Application No: LU/144/20/HH
Site Address: 25 Windward Close Littlehampton BN17 6QX
Description of works: Detached single garage.

Thank you for your internet representation made on 16th July 2020 which has been recorded as an objection with the comments as follows:

proposed block plan

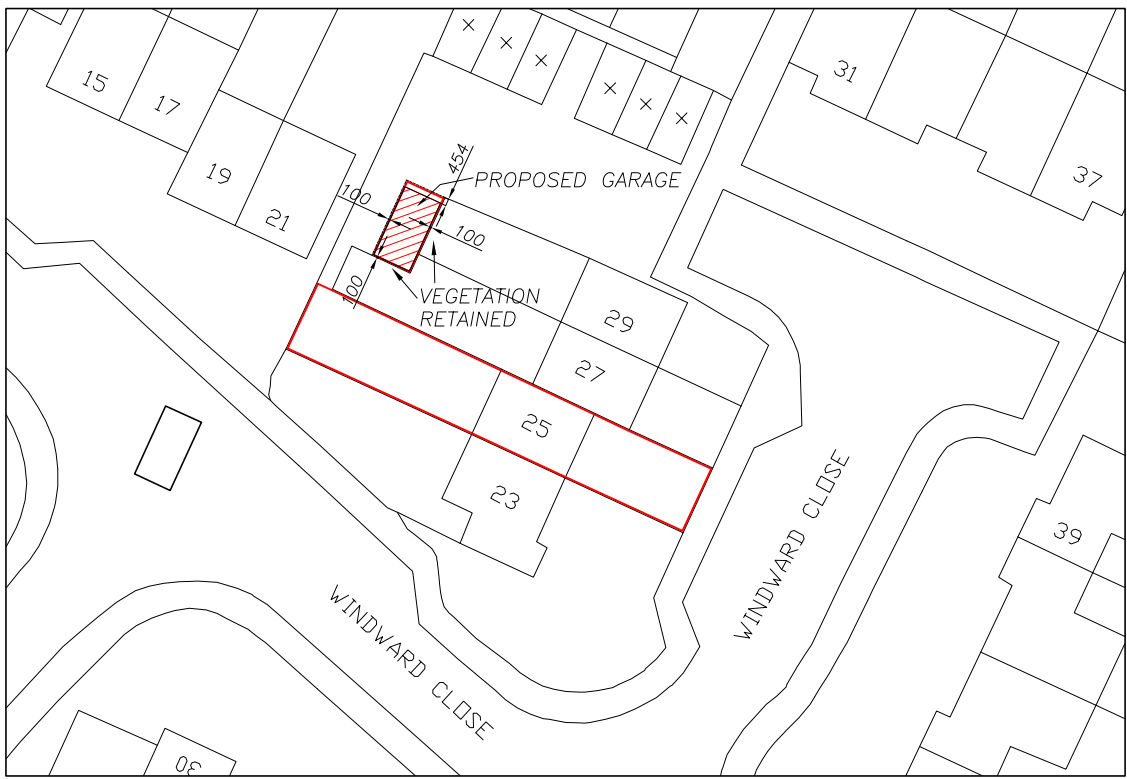
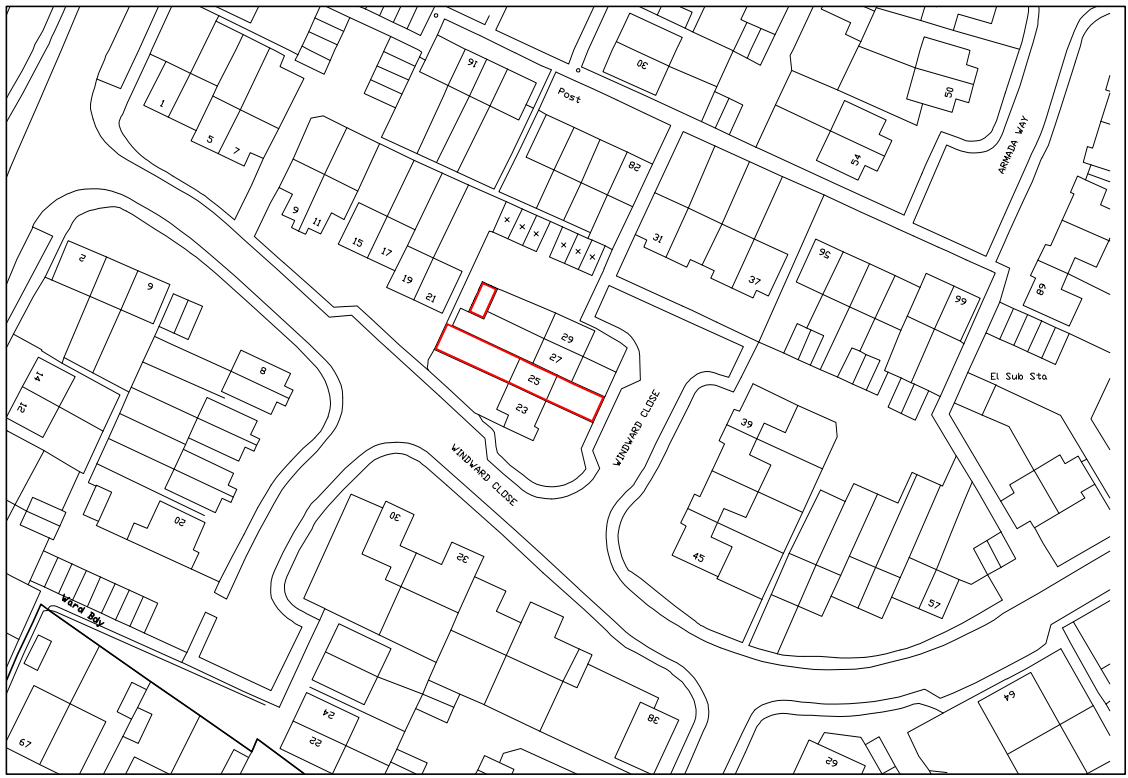
The area in question is suitable for 2 cars. By adding this garage it would remove the option for a second car.

I would also like to bring to your attention, that places that allow public parking should not be removed or compromised, and if you grant this application you would be breaching your own rules (referring to laybys and dropped curbs policy)
